Reference: 1020168 L01D 884-928 Mamre Road Kemps Creek ENV CNVMP DPIE response.doc

RE: 884-928 Mamre Road, Kemps Creek Response to DPIE comments

Acoustic Works was engaged by Altis Property Partners to prepare an environmental noise assessment for a proposed industrial estate to be located at 884-928 Mamre Road, Kemps Creek. This letter has been provided to outline the changes made in the updated acoustic report (ref: 1020168 R01M 884-928 Mamre Road, Kemps Creek ENV.docx dated 26/08/2021) and the updated Construction Noise and Vibration Management Plan (ref: 1020168 R02C 884-928 Mamre Road Kemps Creek CNVMP.docx, dated 26/08/2021) in response to comments from the NSW Department of Planning, Industry and Environment. The comments and changes made in response are provided below.

Figure 9: Barrier recommendations

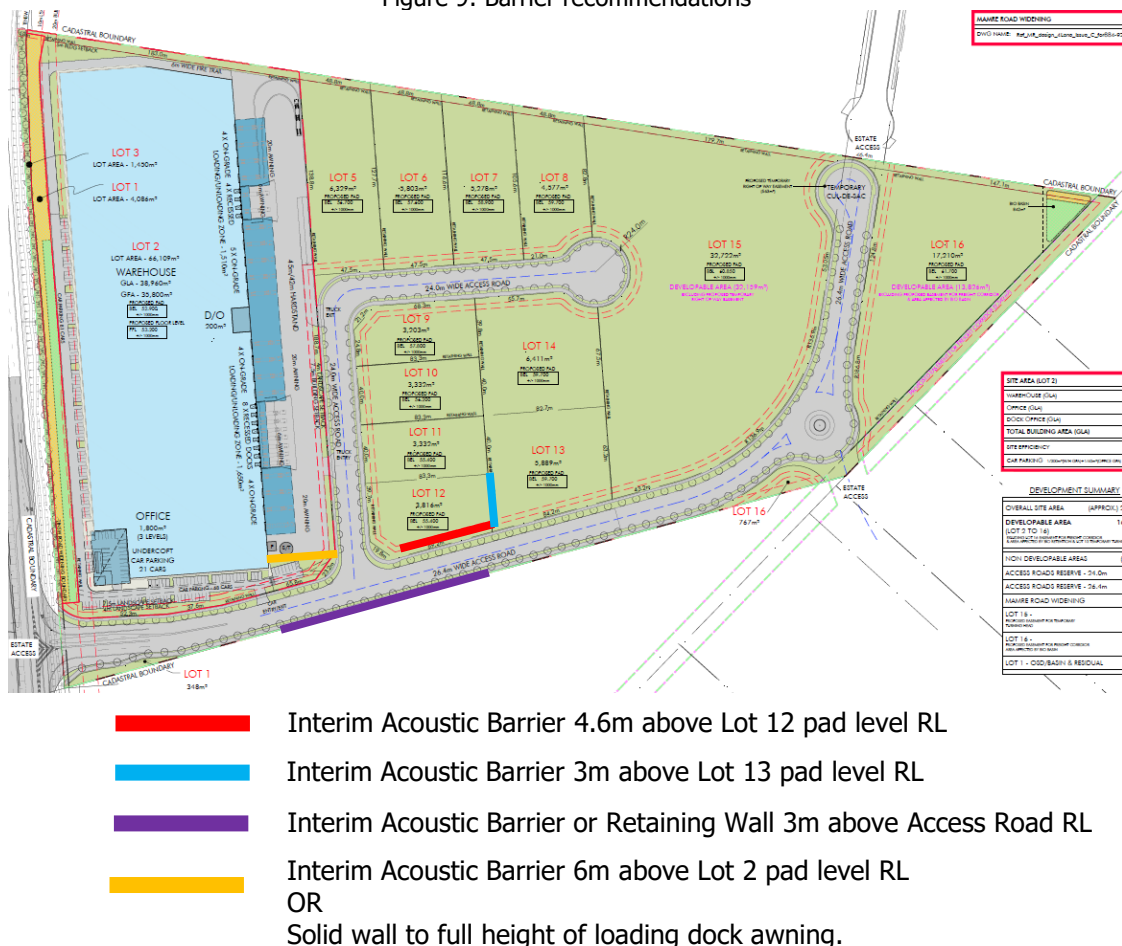
DPIE Comment

"Detail when the acoustic barriers will be installed, how long they will be installed for (the 'temporary' is to be reconsidered) and how these have been taken into account in the noise modelling"

The Acoustic Barriers are to be installed at the construction stage and must remain in place until the relevant residential receiver is no longer occupied. Once the receiver is no longer occupied the barrier may be removed. A semi-permanent construction may be used to facilitate the removal of the barrier, on the condition the barrier is constructed in accordance with the recommendations in Section 12 of the report.
